PCD File Number: ADR184

SITE PLOT PLAN
1110 BECKEY DRIVE
"SIDE YARD SETBACK
VARIANCE REQUEST"

Markup Summary

SITE PLOT PLAN
1110 BECKY DRIVE
"SIDE YARD SETBACK
VARIANCE REQUEST"

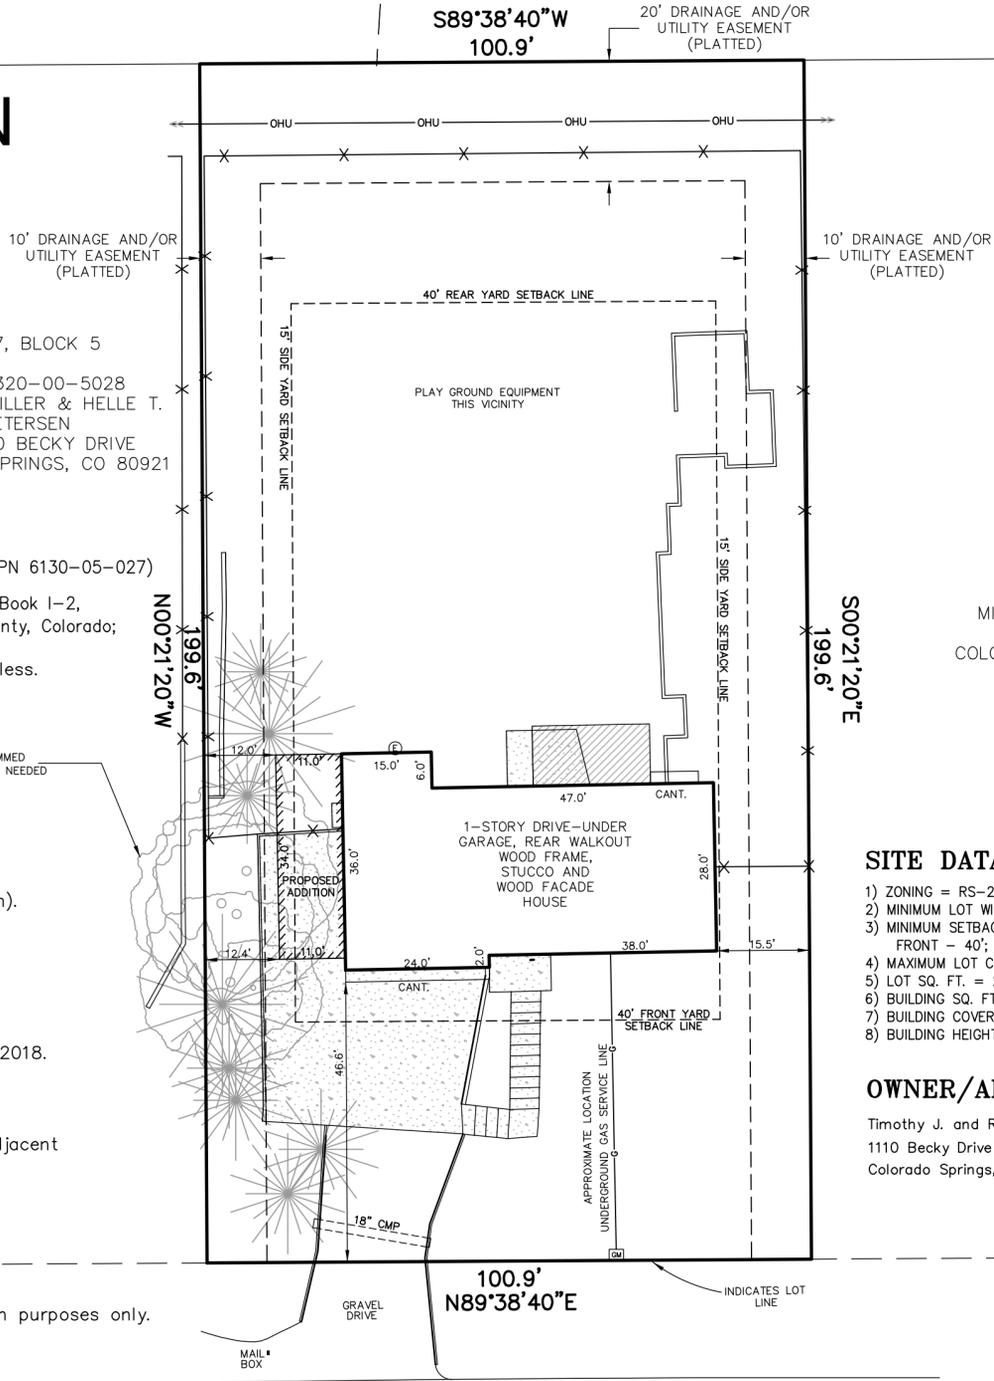
These are in the setback, even further than 12 feet, if these are depicted on the site development plan that would require a Board of Adjustment Hearing for a setback variance.
